Date 29 April 2022  
Our Ref 22/00511/FUL

**Town and Country Planning Act 1990 (As Amended)**  
**6 Maidenshaw Road, Epsom, Surrey**  
**Conversion of garage into habitable space, single storey rear extension, extension to dropped kerb and alterations to driveway**

<b>H.M. LAND REGISTRY</b>		TITLE NUMBER	
		<b>SY125161</b>	
ORDNANCE SURVEY PLAN REFERENCE	TQ 2061	SECTION P	Scale 1/1250
COUNTY SURREY	EPSOM AND EWELL DISTRICT		© Crown copyright 1961

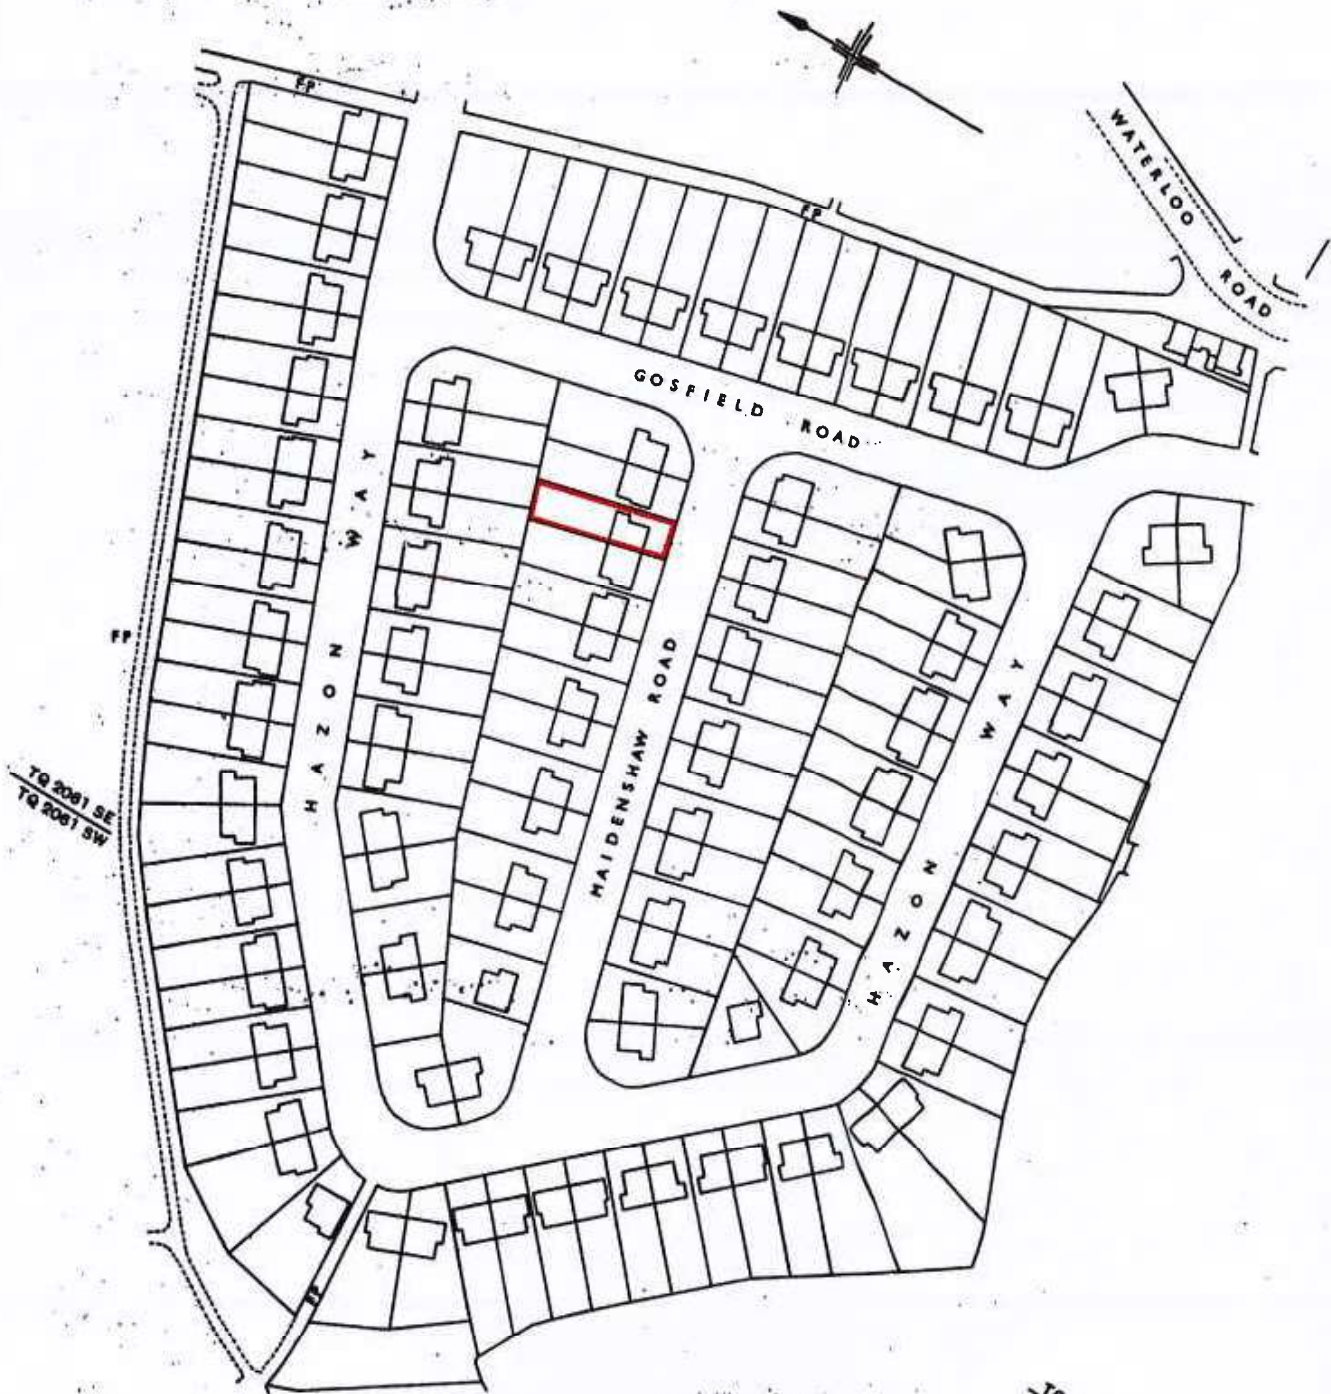
1 The red line boundary should include all land necessary to carry out the proposed development, which includes land required for access to the site from a public highway. As the proposal would require an extended vehicle crossover, this needs to be included within the red line of the location plan. Please ensure that Certificate B is completed and served on the landowner of the public highway, which is Surrey County Council Highway Authority.
